Re: Application No: SSD-10395 –Cleanaway’s Western Sydney Energy and Resource Recovery Centre

We refer to the SSD application for Lot 1 DP 1059698 and make the following comments as an adjoining owner.

Figure 10: Wallgrove Road / Austral Bricks Road – Gazcorp Industrial Estate 2021 layout

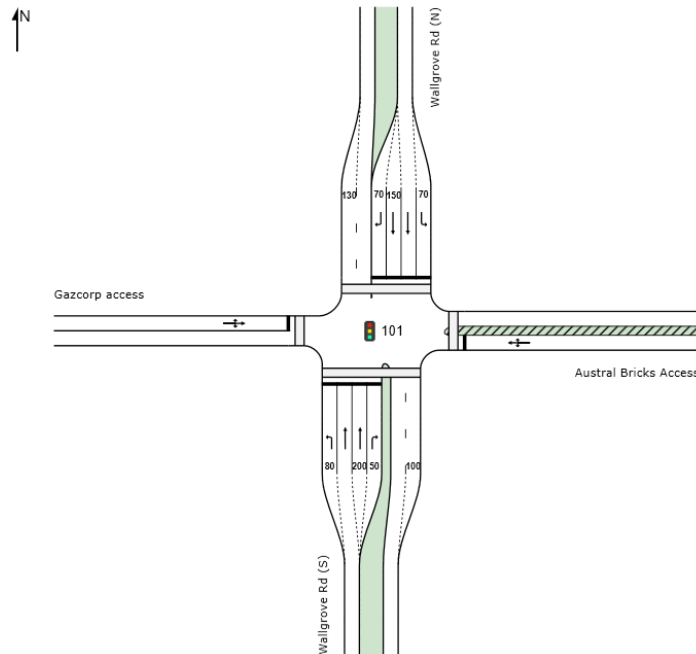
We confirm that the Austral Bricks Road intersection with Wallgrove Road has traffic issues which can only be addressed by signalisation. We note that the submission assumes that this work is undertaken by Gazcorp, as part of its development of land to the west of the intersection.

We are concerned that if Gazcorp does not commence its DA and undertake the signalisation works the intersection will fail when Cleanaway’s operations begin.

We thus propose a condition that the signalisation works be completed as part of this SSD, if they are not completed by others prior to the commencement of construction works for the Centre.
